Rezoning Transportation Analysis

Petition Number: Insert Zoning Petition #2021-023

General Location Identifier: Tax IDs: 22327148, 22327149, 22327150, 22327151, 22327152

Date	Description
02-25-2021	First Review (LJ)
03-25-2021	Second Review (LJ)

DEVELOPMENT STANDARDS March 15, 2021

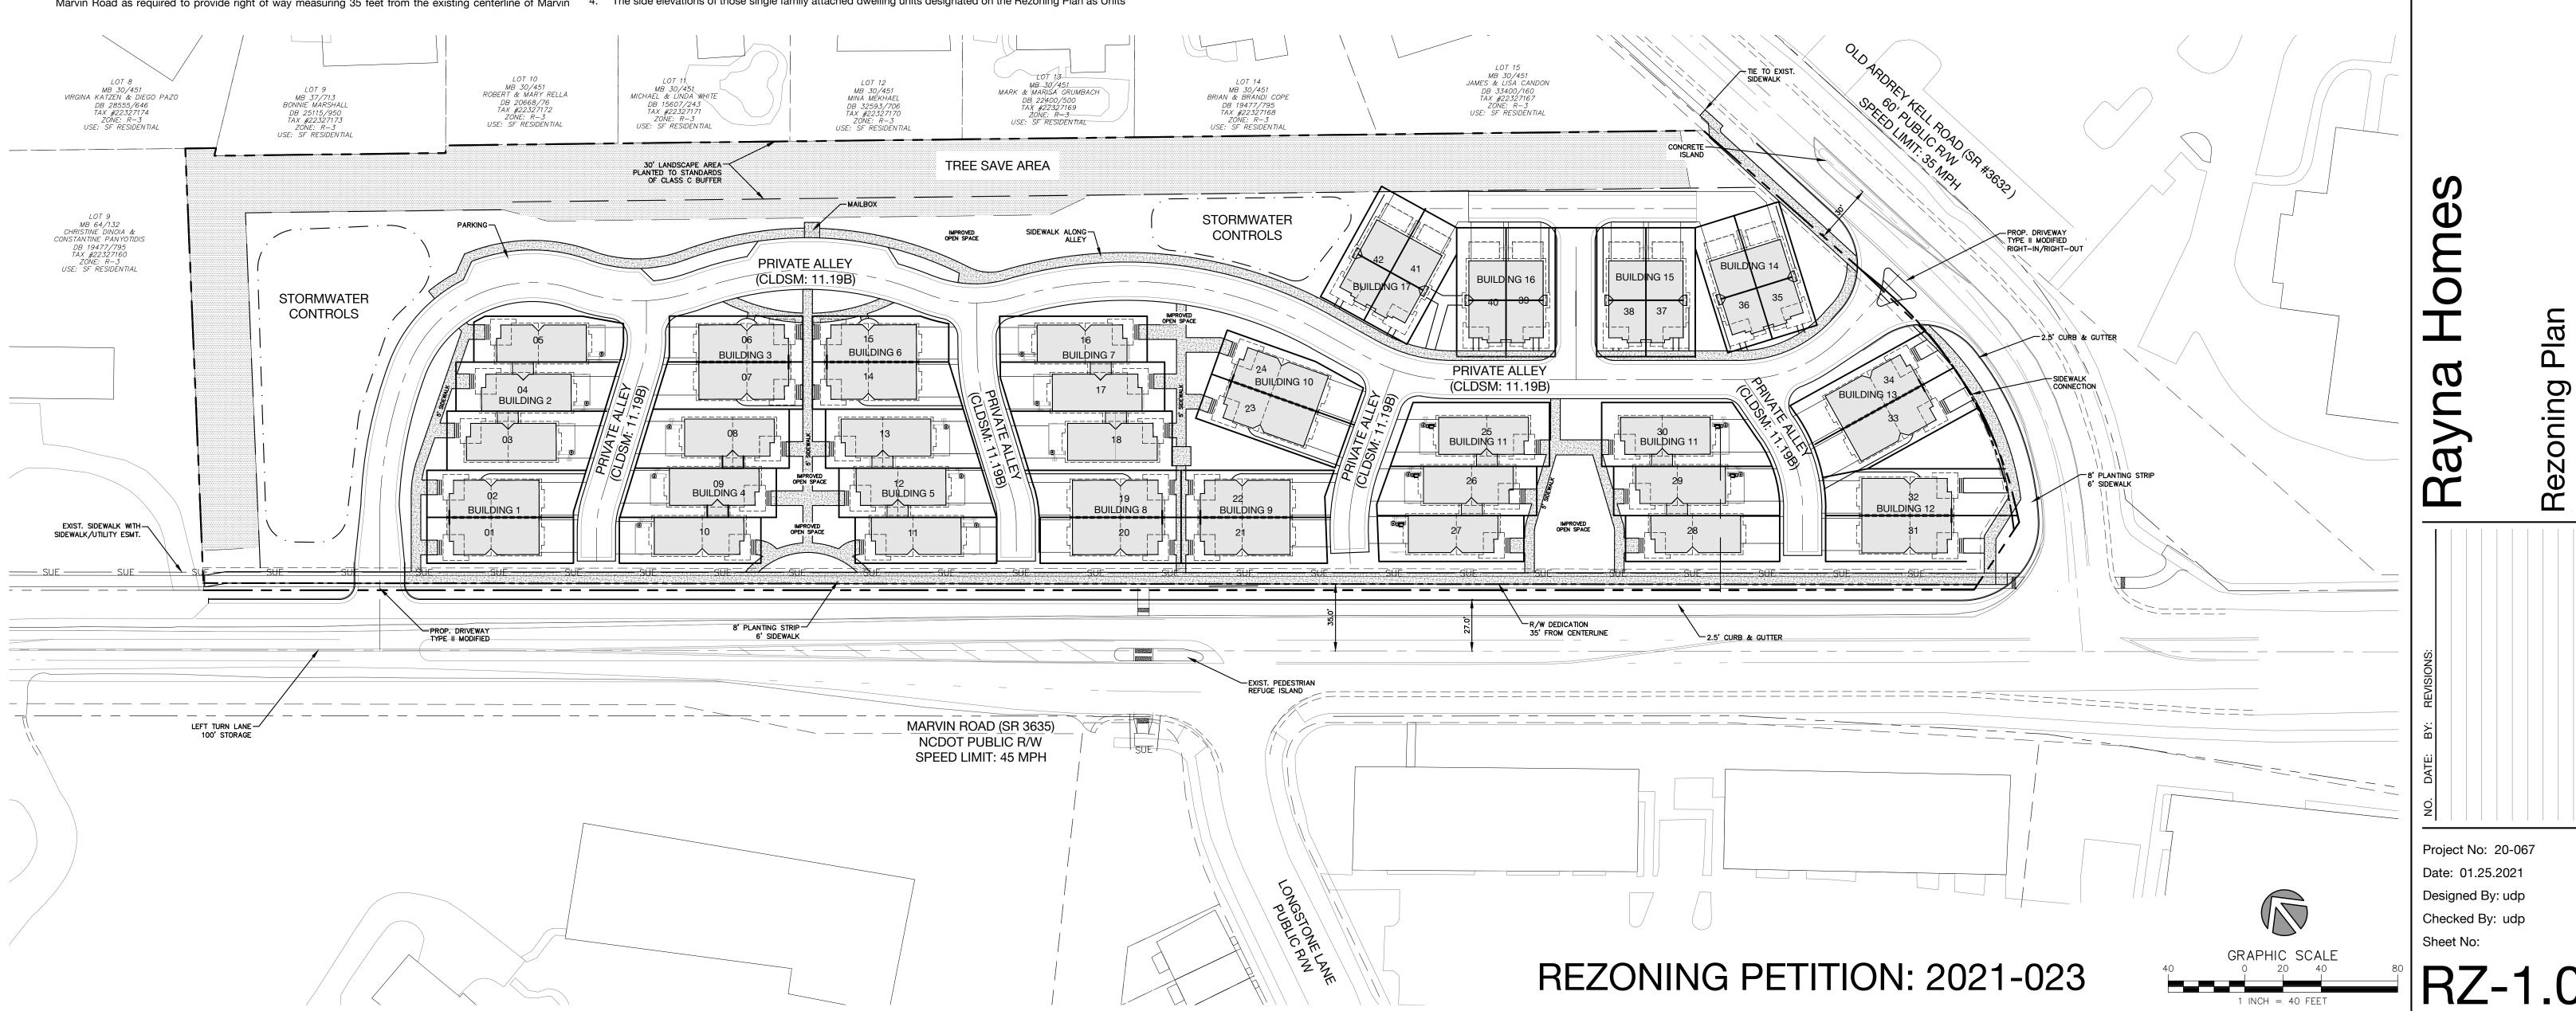
1. ~~Curbline:~~ The proposed zoning district has a setback measured from back of the existing or proposed future curbline.
 - a. **Resolved (03/18/2021): Marvin Road (NCDOT):** The future location of back of curb and gutter is 27' from the Marvin Road centerline. Label and dimension the curb and gutter from the centerline for each road on the site plan.

- b. **Resolved (03/18/2021): Old Ardrey Kell Road (NCDOT):** Location of curb and gutter is in its existing location.

Label and dimension the curb and gutter from the centerline for each road on the site plan.
2. **Traffic Study:** A Traffic Impact Study (TIS) is not necessary for the complete review of this petition due to the site generating less than 2,500 daily trips. If during the permitting process the site generates more than 2,500 daily trips, then a traffic study will be required.
3. **Resolved (03/18/2021):** ~~Revise site plan and conditional note(s) to commit to dedicate 35' right-of-way on Marvin Road from the road centerline. The site plan shall label and dimension the right-of-way from the road centerline.~~

4. **Resolved (03/18/2021):** ~~Revise site plan and conditional note(s) to commit to construct an 8-foot planting strip, and 6-foot sidewalk on Marvin Road and Old Ardrey Kell Road per Chapter 19 / Chapter 20. The site plan shall label and dimension both items from the back of curb and gutter and road centerline.~~

5. **Resolved (03/18/2021):** ~~Provide a left turn lane on Marvin Road as required by NCDOT. Restripe Marvin Road, per NCDOT Roadway Standard Drawing for PAVEMENT MARKINGS Turn Lanes, 1205.05, to accommodate the left turning lane to include 100' storage.~~

6. **Resolved (03/18/2021):** ~~Petitioner will relocate the driveway access point on Marvin Road, as shown per NCDOT, and provide 100' driveway stem.~~

7. **Resolved (03/18/2021):** ~~Petitioner will relocate the driveway access point on Old Ardrey Kell Road. The access point will be a RI/RO with a porkchop median and a center median that will begin from the driveway across the street and continue to the end of the Left Turn Lane (LTL) taper to Marvin Road, as shown per NCDOT and provide 100' driveway stem.~~

8. **Resolved (03/18/2021):** ~~Site plan and conditional note(s) revisions are needed to meet CLDSM standards as required by NCDOT. Provide a pedestrian refuge across Marvin Road, per CLDSM, 11.41, complying with ADA/PROWAG standards. The pedestrian refuge also meets the Charlotte WALKS Policy.~~
